**WEST SUSSEX COUNTY COUNCIL
STRATEGIC PLANNING CONSULTATION**

SUBJECT: R/82/14/PL - Application for the variation of conditions 2 & 11 of previously approved planning permission R/59/12 - relating to approved plans & parking/cycle spaces

LOCATION: Sainsburys Supermarkets Ltd, Unit C, New Road, Rustington, West Sussex, BN16 3RT

RECOMMENDATION:

Proposed Site Plan
Ground Level

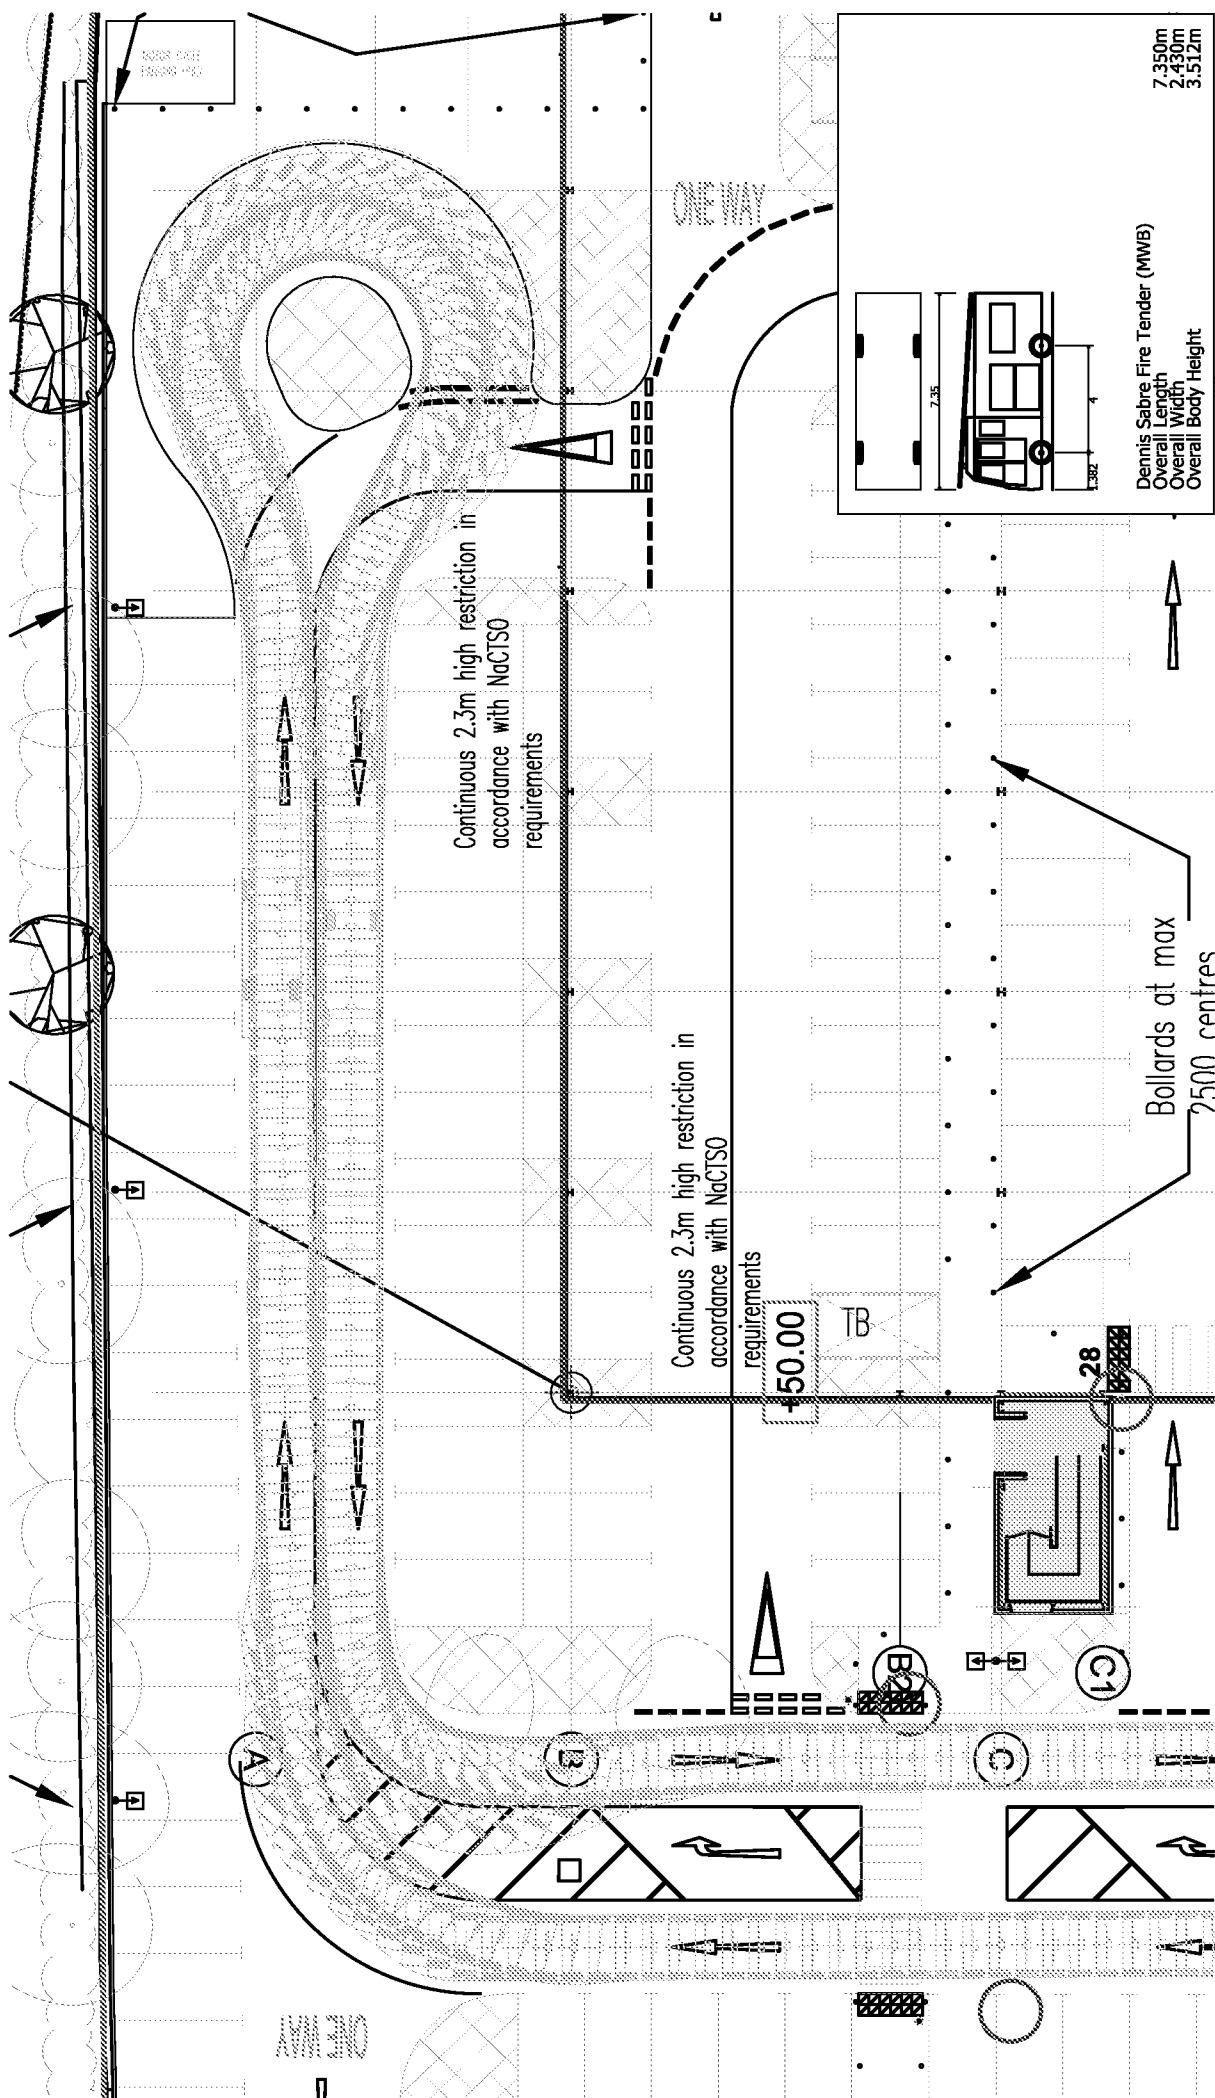
1. Number of staff employed on-site
2. Average number of staff on-site at any one time
3. Number of staff on-site during peak periods
4. Travel modes used by staff
5. Number of staff who regularly drive to the site and park their car on-site
6. Maximum number of staff parked on-site during busiest periods (survey information taken at the site should be provided)
7. The methodology used to determine staff parking numbers
8. A plan showing space for 50 cycles (space for only 44 cycles is shown on drawing CHQ.11.9647 – PL05E)
9. A plan showing swept-path/Autotrack diagram of fire appliance entering, negotiating and leaving the site
